TEXT_M25J28_ISH1_Session3_03032021

Thank you, Mr. Allen. So yes, moving on to access to an egress from Grove farm. And so the deadline to the owners of growth forms submitted via their representatives. So proposed amendments to the applicants proposals for access to an egress from growth, the growth on site.

Client	MR L JONES & MRS K JONES			Scale	1:1000
	FOR APPROVAL				Drawn
Project	GROVE FARM ACCESS, JUNCTION 28 M25 NORTHBOUND SLIP LANE				
	ACCESS ALTERATIONS TO GROVE FARM				
Status	Sheet Size	A3	Date	JAN 2021	Rev
		Drawing No.	REDW-3396-110

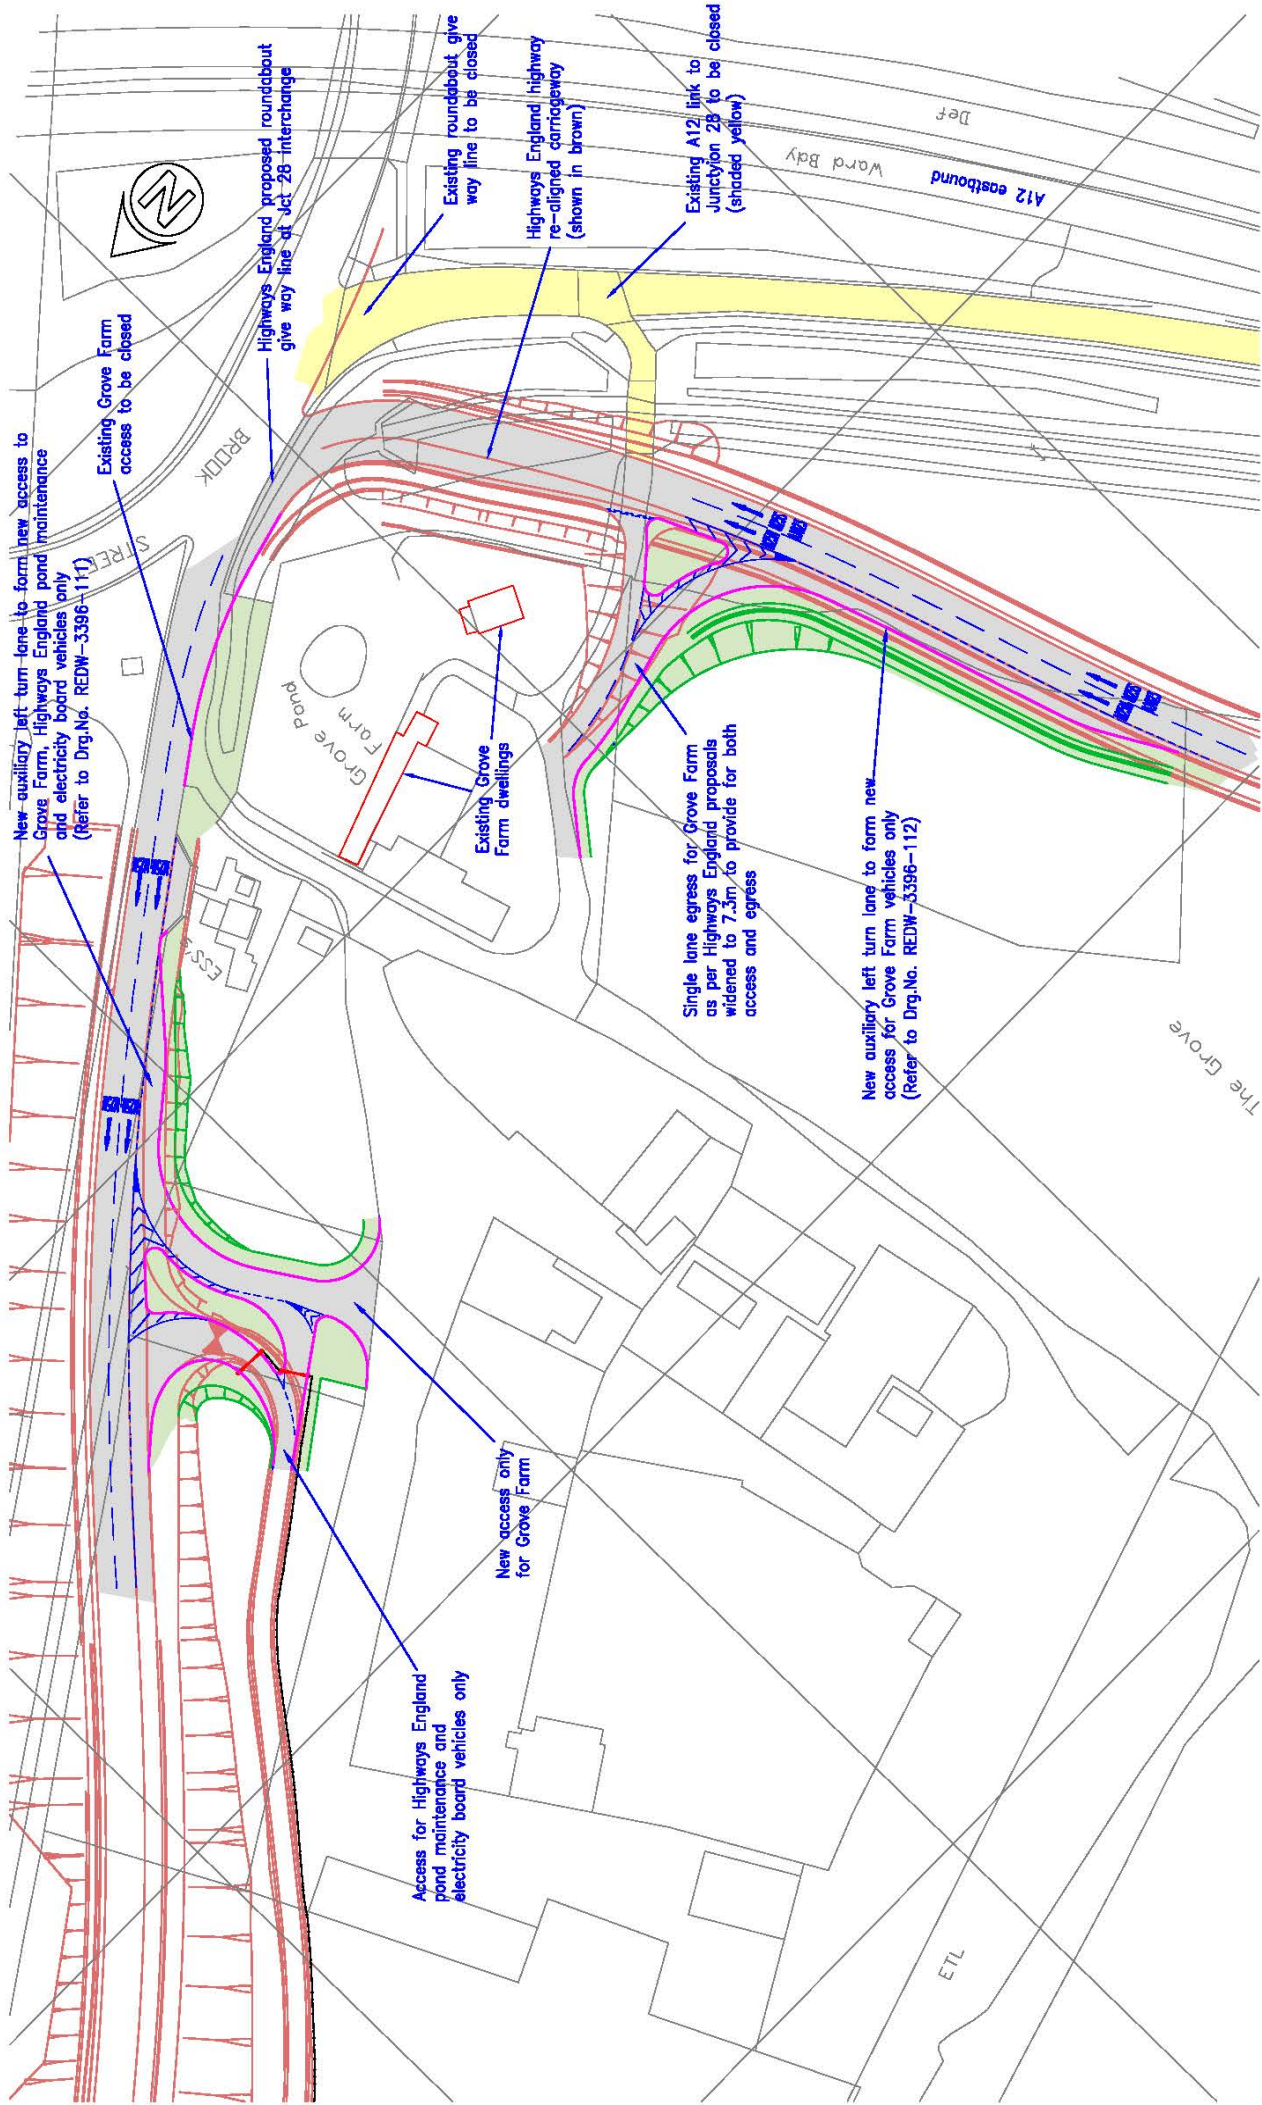
you can you can clearly see on my drawing 3396110 you can clearly

see the location of the existing a 12 piece bound off slip which I've coloured in here.

And I've also on that drawing superimpose the new alignment for the K 12 eastbound on slip.

You have at least 40 metres of curb line once you depart from the age quo

on your left before to the slip lane entry to the farm with the realigned a 12 that 40 metre is

is cut back to it's difficult to save in the plans that have been published to the maximum 10 metres possibly down to five metres or zero even.

turning left into the 25 there is inadequate time for left indicators and vehicles to switch off

of vehicles coming from the a 12 still be on confusing them with indicators for vehicles entering the farm. So, this this this distance between the new alignment for the a 12 pack and the existing entrance in my opinion is far too short and will

consist of a safety issue. So the proposal is to move the existing access to the farm north on the north side of the electric substation. laybuy provide a short admittedly is it substandard but a short deceleration lane into the farm in a new location. This

And you can see from my drawing 3396110 I have notated where the three dwellings are, there's obviously the main farmhouse and

digital versions of the proposals on a base survey base, ideally, but all we got from highways England was the digital layout of the proposals but that they weren't located on an Ordnance Survey plan or a survey base. So the plan that you see in front of you 3396110

that is my best interpretation of where the proposals which are shown in brown, which I received from I was England, how they fit on an Ordnance Survey plan. Clearly, clearly we don't have we have asked, but we hadn't received, we don't have a digital copy of the topographical survey, or, or an accurate

digital version of the proposals on a accurate base plan. So the brown alignment is the digital alignment received from highways England, but it where it sits on the Ordnance Survey plan is my best guess as to where it sits on the ground.

but relocating the ingressive further north along the 25 on slip road will place it where heavy vehicles are accelerating towards the merge with the 25 hour road safety and operational status specialists have raised concerns that such a relocation will be unsafe. Vehicles breaking into ground farm may cause collisions

They've also raised concerns that vehicles could exit row form via the ingress and turn right into the slip road resulting in head on collisions. That's a problem apparently elsewhere on the I was in the network and they flagged that up for my attention.

They just think egress is located close to the stop line where vehicles are slowing down. Again, there are no recorded accidents at this location on the current layout.

And even Gresham, the 12th will introduce an additional movement. This will create further hazards for through traffic as vehicles break for the diverged way, slip road traffic is travelling faster, being further away from the stop line is level of provision for private access could also be confused with the 25 on slip. And again, our road safety and operational safety specialists have raised concerns that such a provision will be unsafe

as picked up by Matthew Rheinberg evade taxes on slip roads are not permitted in the design standards. There will be departures from standards and operational safety will be material consideration in the departure approval review.
